January 15, 2009

**RE: Tumbling Ridge PUD Rezone (Z-07-16) and Preliminary Plat (P-07-61)**

SHEET 1 OF 3

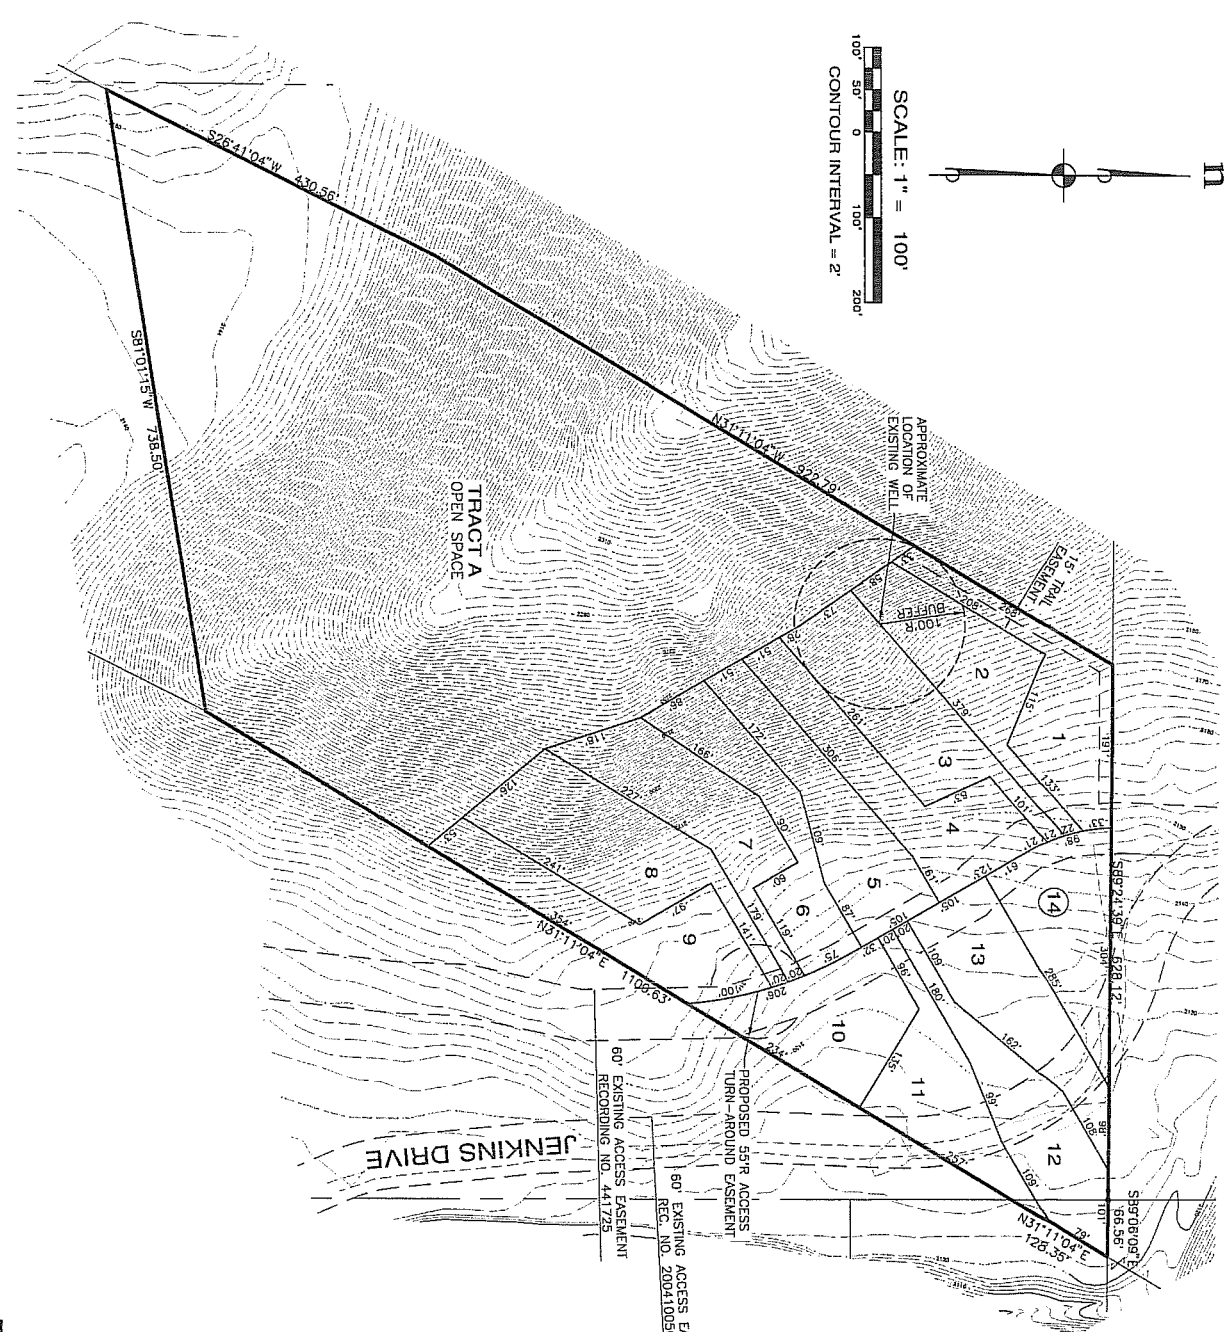
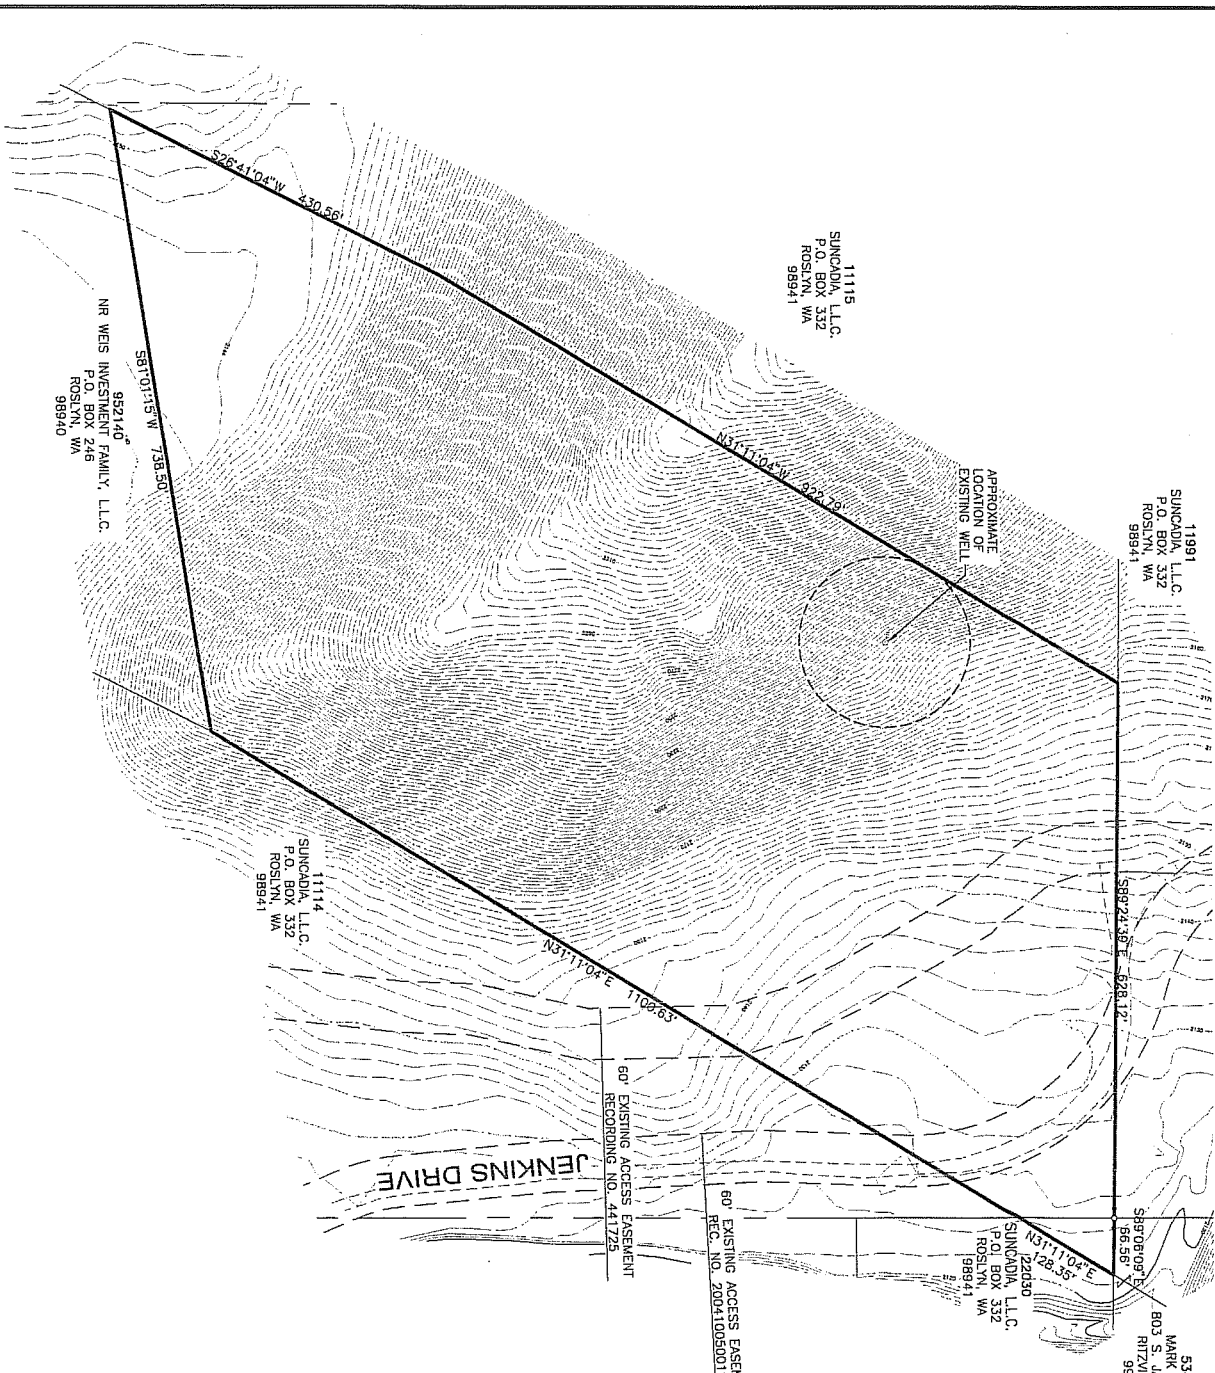
Based on the plat drawing submitted by the applicant with this application, the proposed road layout traverses Jenkins Drive to the north of the northern boundary of the applicant's property and then makes a sharp turn to the south reentering the applicant's property. Based on the map attached to the Road Use and Easement Agreement the applicant's easement terminates at the northern boundary of the applicant's property. Thus the road system proposed is not entirely within the Jenkins Drive easement and would, if constructed as shown, constitute a trespass on Suncadia's property. Presumably, this configuration is proposed due to topography and the need for lesser road gradients, which is further proof that this site is simply not suitable for this development.

In a meeting with Suncadia representatives the applicant, when confronted with this fact, conceded Suncadia is correct and that a portion of the road system would enter onto Suncadia property with no easement rights. Suncadia will not agree, under any circumstances, to grant the applicant additional easement rights to accommodate this road. The applicant indicated it would change its road design,

but has not done so. A plat application that does not show complete, legal access cannot be approved.
